Your Ref :
Our Ref : P/22/19/NMA

Section 96A of the Town & Country Planning Act 1990 (as amended)
Town and Country Planning (Development Management Procedure) (England) Order 2015 (as amended) - Article 10
Non-material amendment following the grant of P/49/18/HH for amendment fo ground floor elevation door & internal layout.
39 Conway Drive, Pagham, ,

CLIENT	Mr Minden Hanley
SITE ADDRESS	39 Conway Drive Bognor Regis West Sussex PO21 4XD
DRAWING TITLE	Proposed Front and Rear Extensions Proposed Plans and Elevations
SCALE	As shown
DATE	March 2018
REFERENCE	39 Conway Drive
DRAWING No.	002
REV.	D

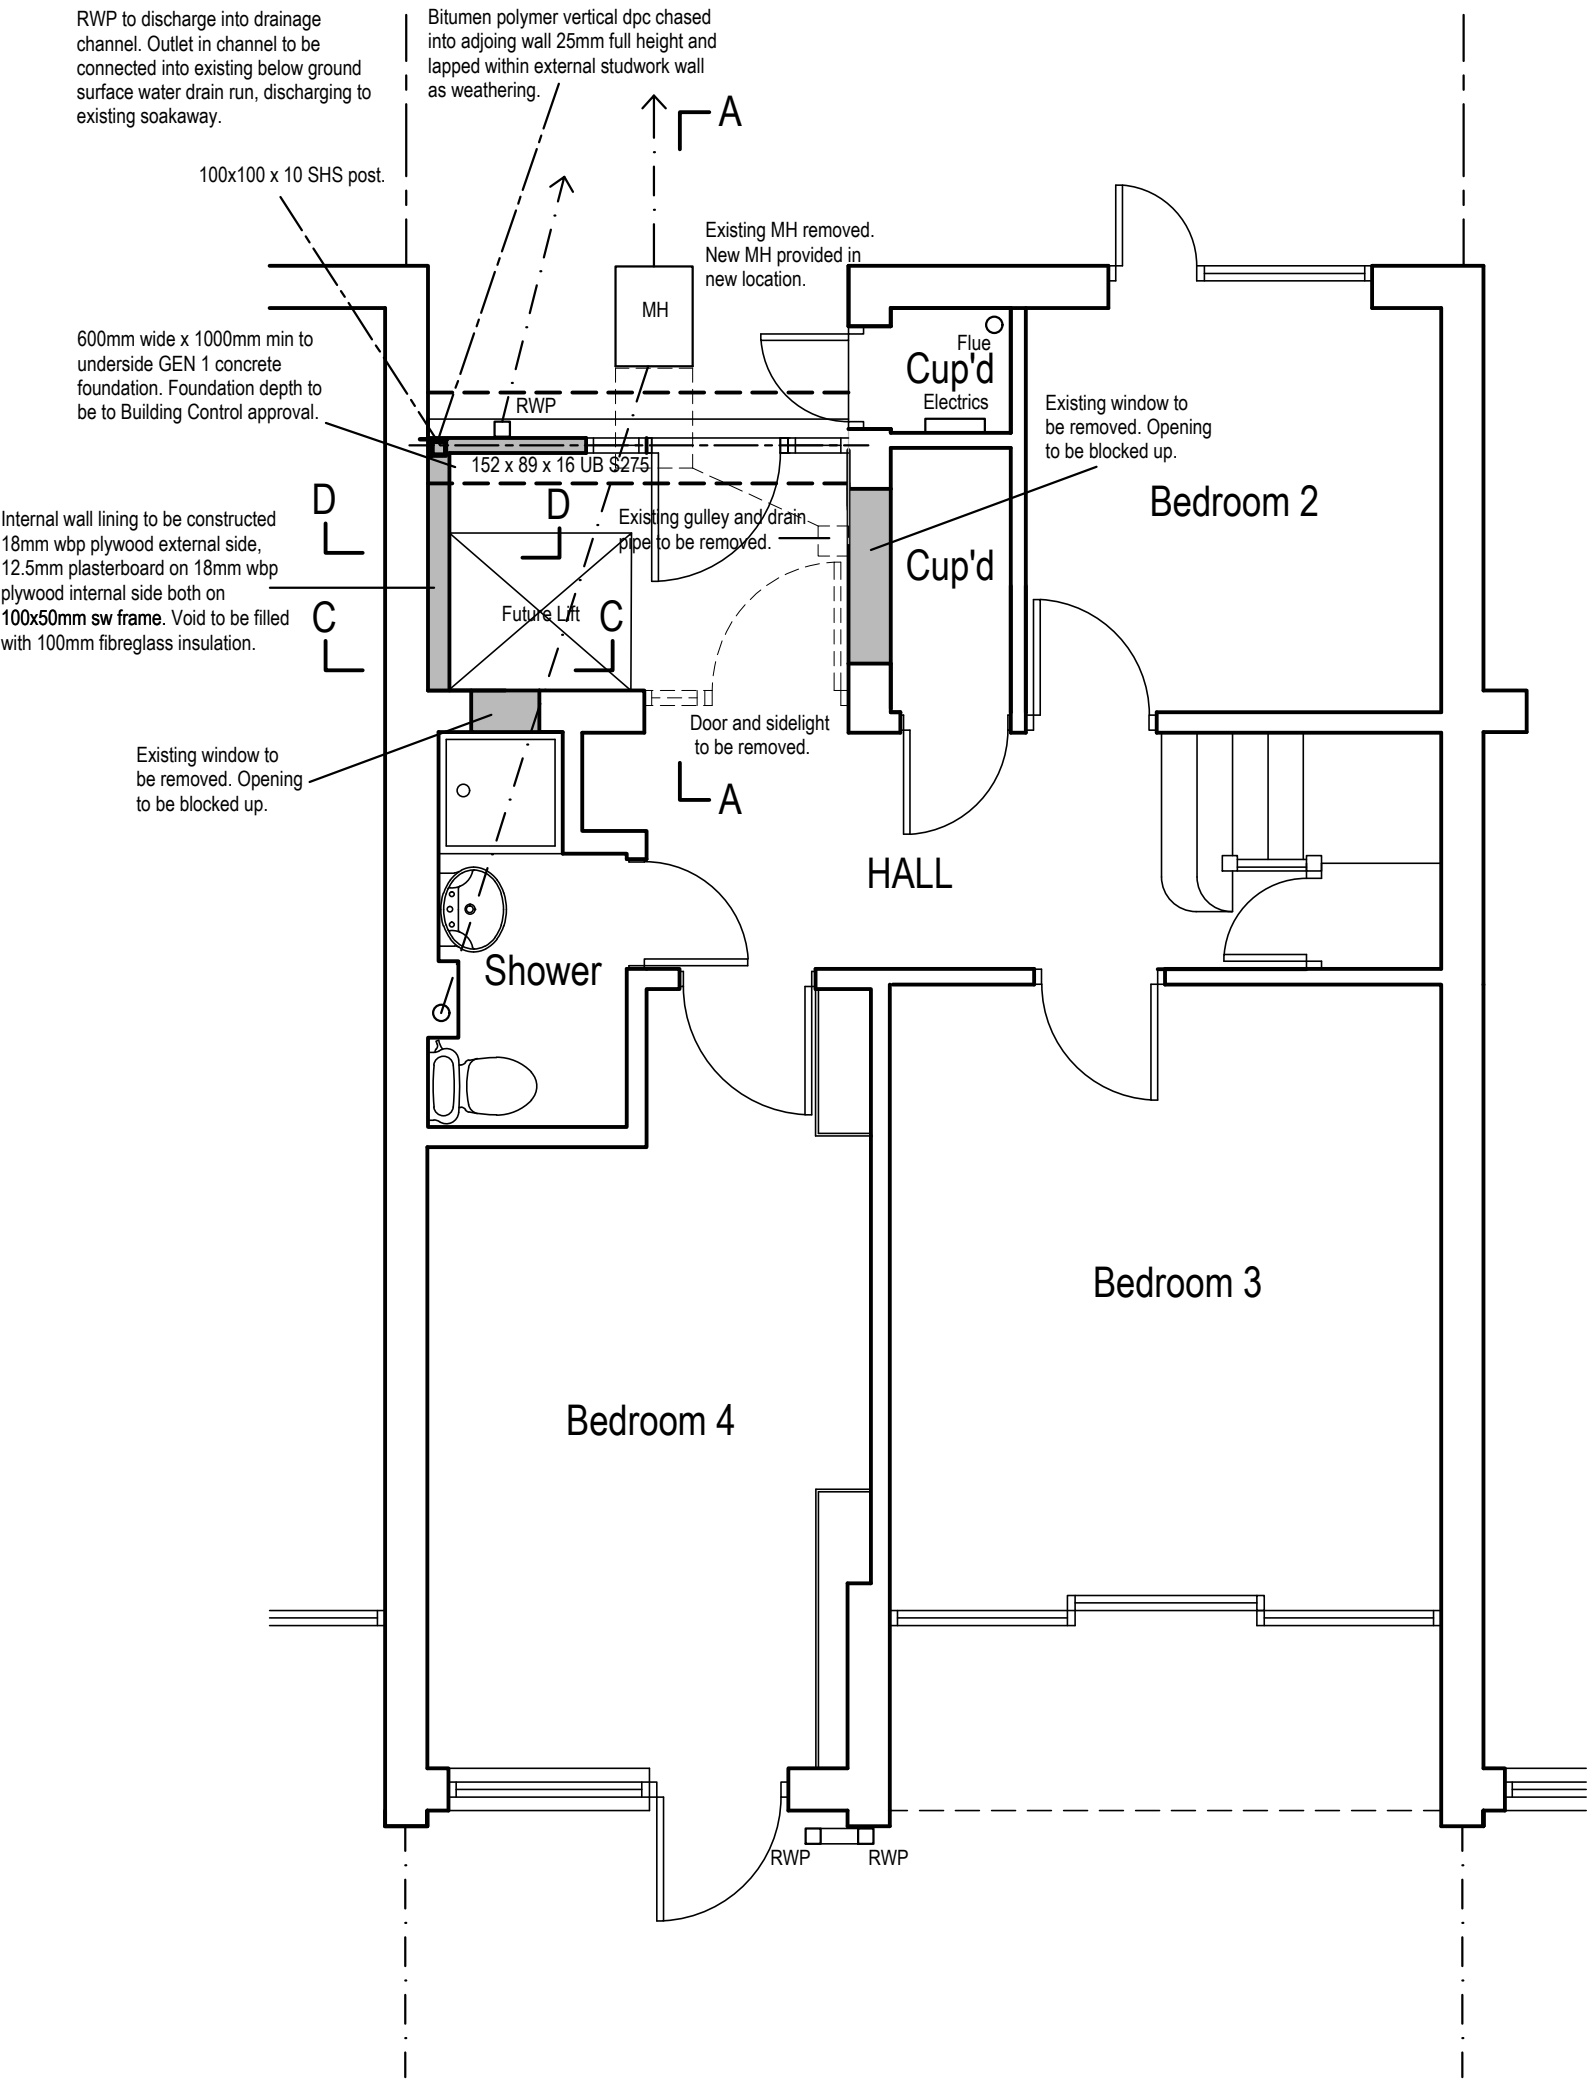
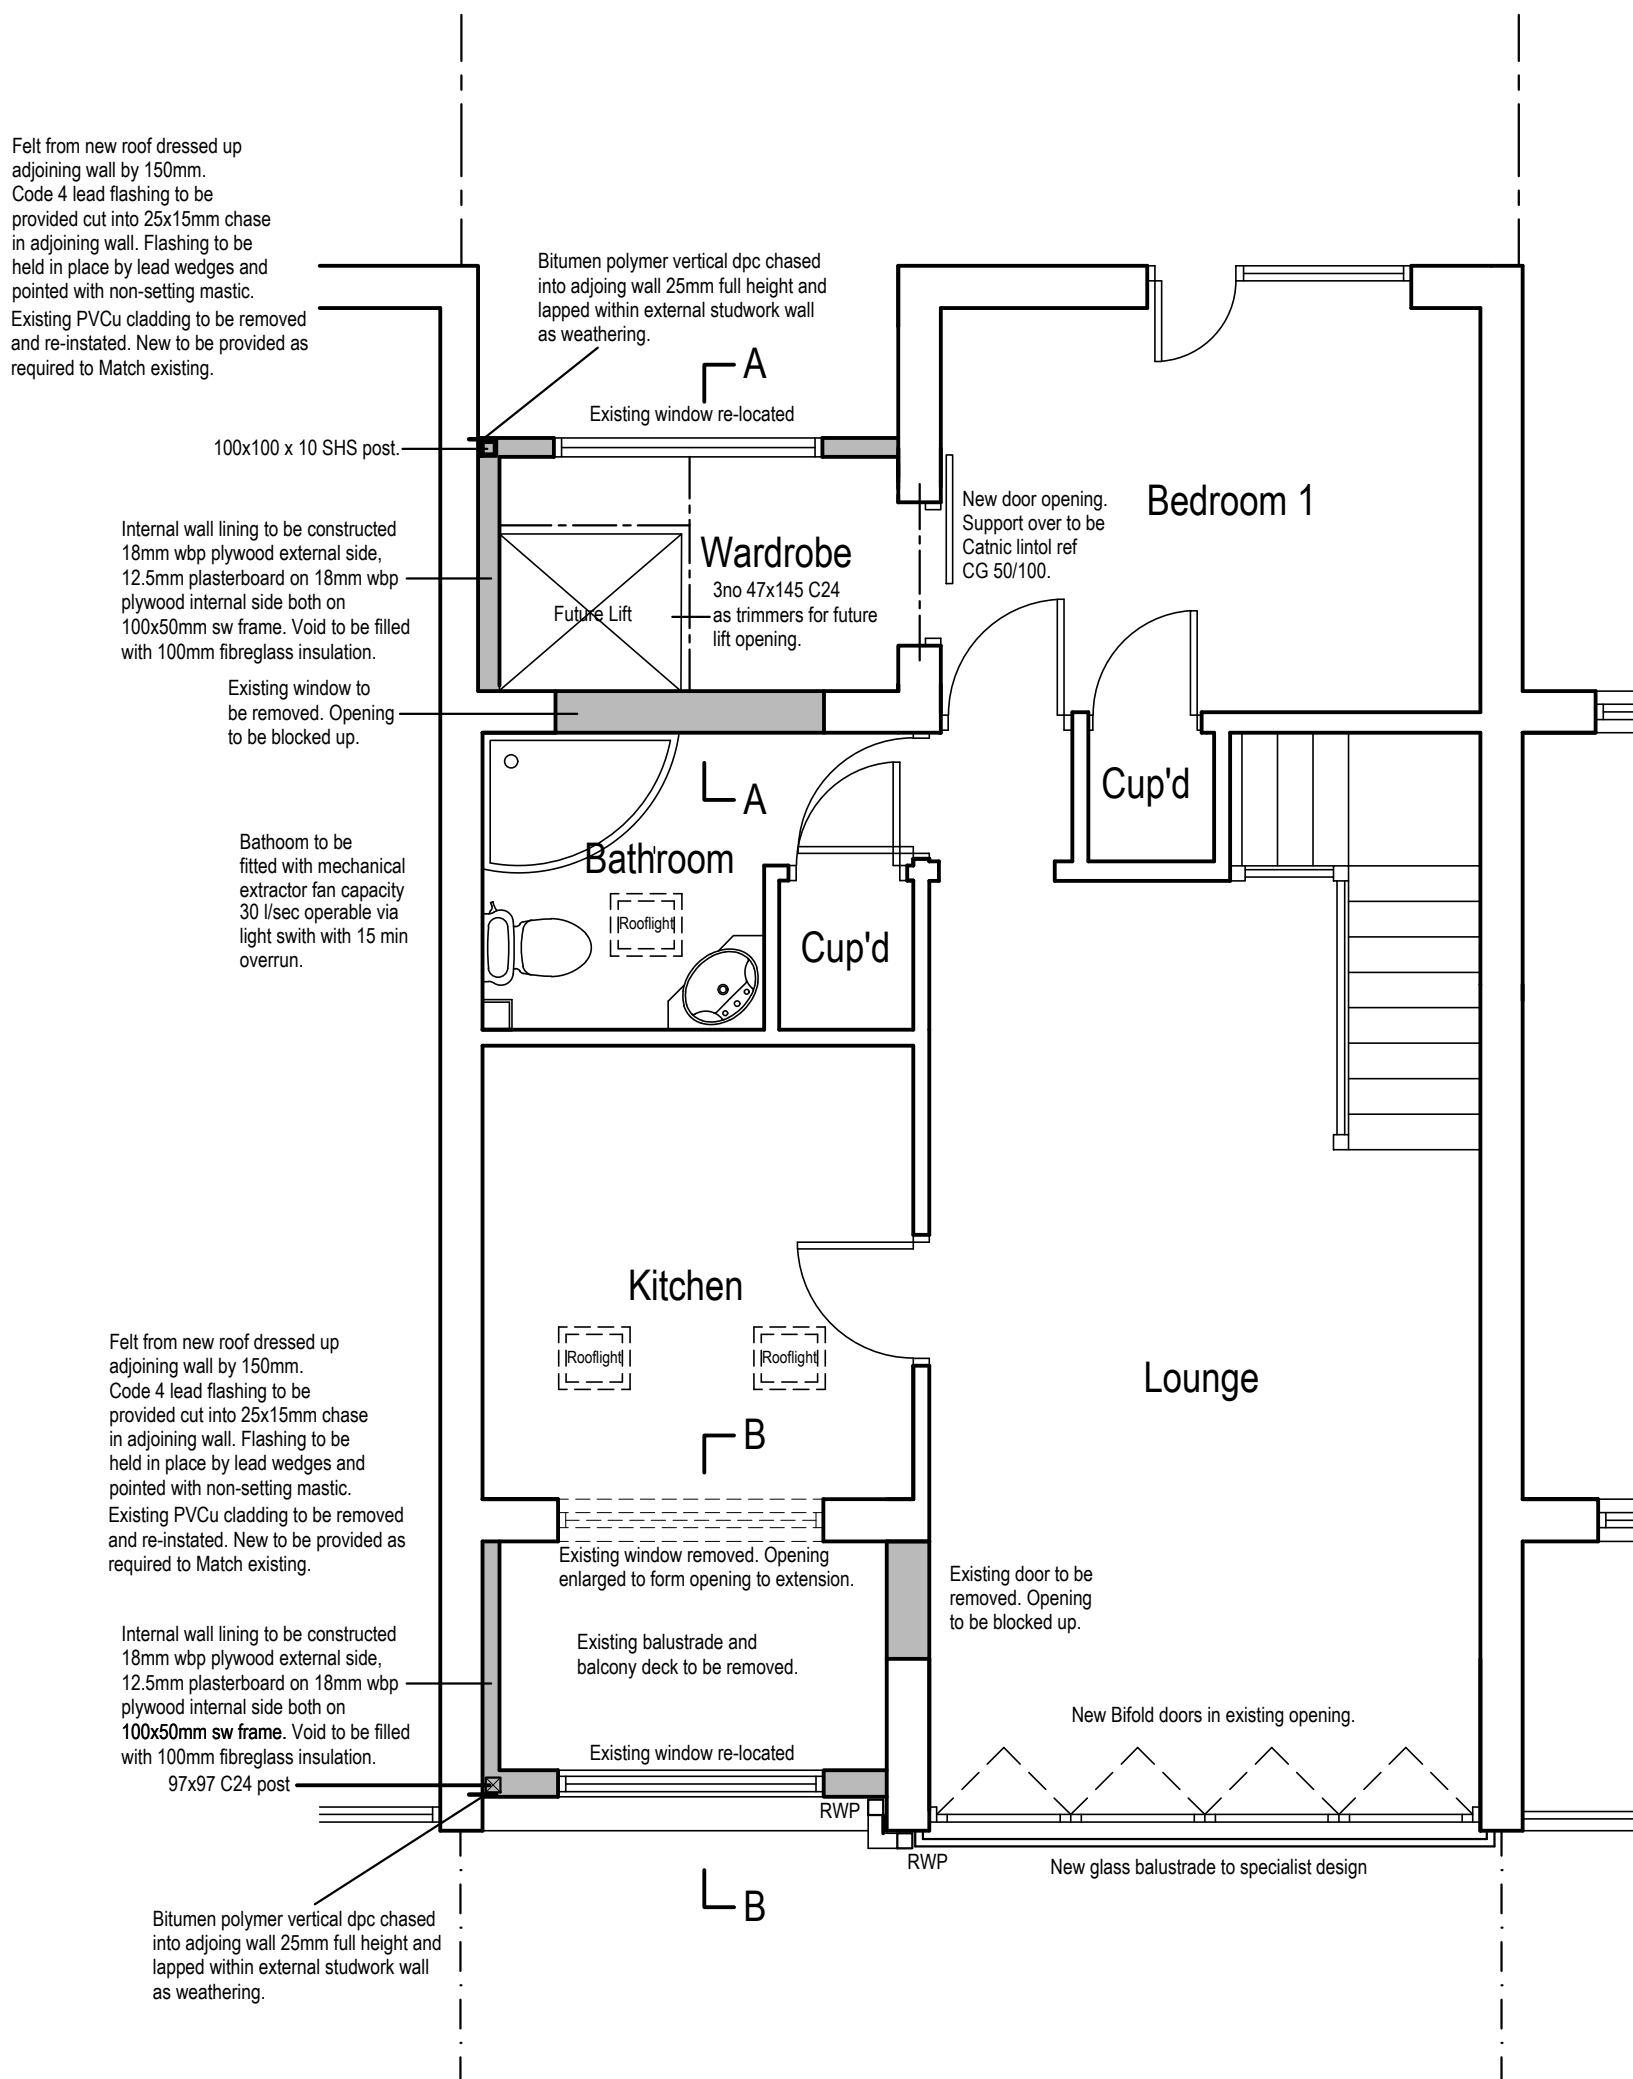
- (a) amend the ground floor front elevation by removing the external store (and the corresponding door) and replacing with a different front door design in a slightly different position; and
- (b) amending the internal layout to match the revised ground floor elevation.

Please note that the drawing 002 Rev D "Proposed Front and Rear Elevations, Proposed Plans and Elevations" now becomes part of the approved scheme and replaces drawing 002 Rev A.
